Horsley Drive Business Park - Stage 2-Mod-3 (SSD-7664-Mod-3)
Request for additional information

I refer to the assessment of the modification application for the Horsley Drive Business Park - Stage 2 (SSD-7664-Mod-3) and note it has been lodged with the Department for determination to assist in the facilitation of SSD-17161650 to which the Department is currently considering. The Department requires the following additional information before it can finalise the assessment of SSD-7664-Mod-3:

4.1.4 Appendix A

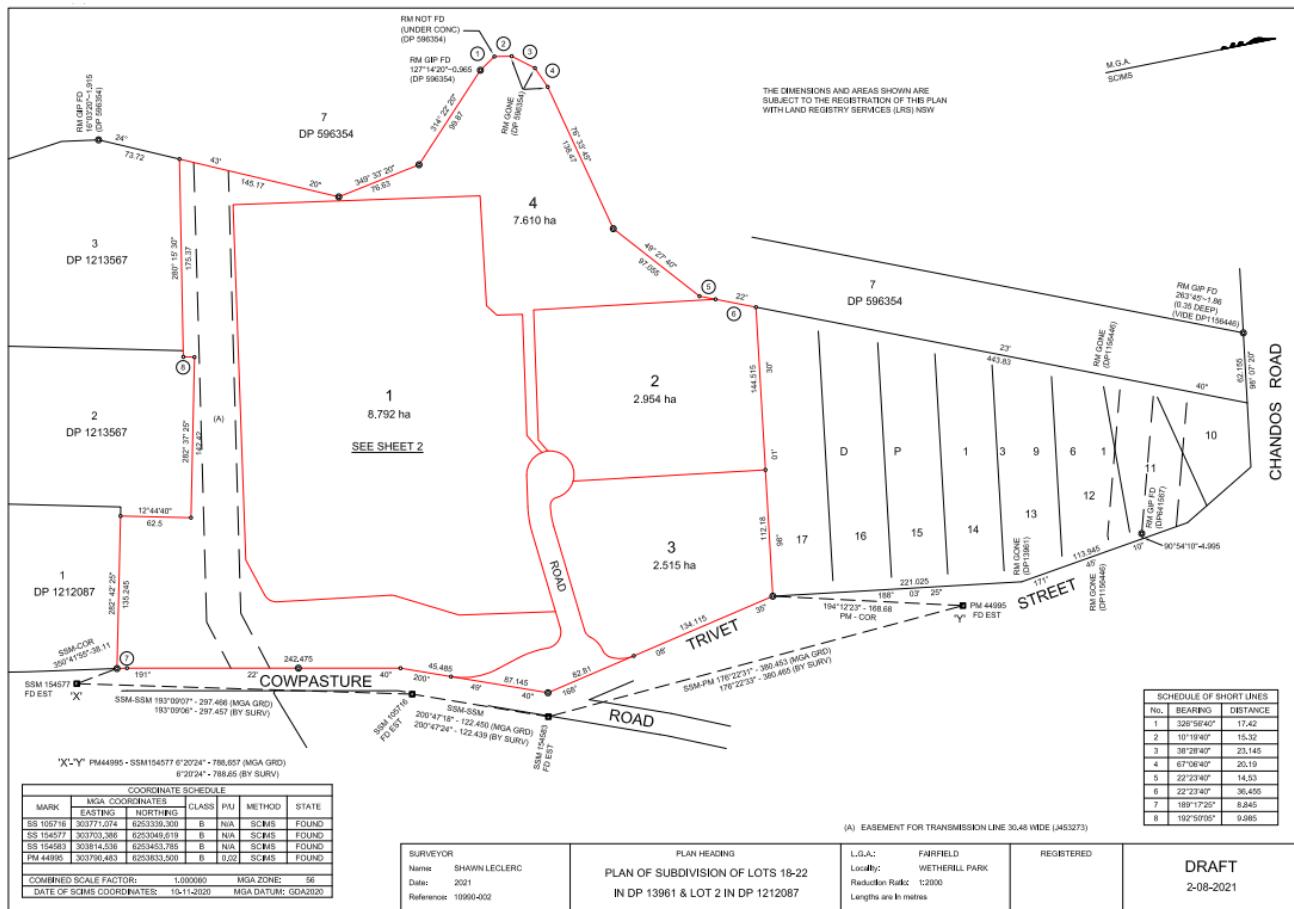
- the proposed lot size changes between the approved and proposed Lot 2 results in a gain of 0.245 ha whereas proposed Lot 3 results in a loss of 0.248 ha. Could you please clarify the exact extent of the proposed changes between Lots 2 and 3?
- confirm that the current draft amendments to the design of SSD-1716150 do not impact on SSD-7664-Mod-3 and the scope of the modification as currently proposed (as lodged), and that there are no impediments to the Department's determination of SSD-7664-Mod-3?
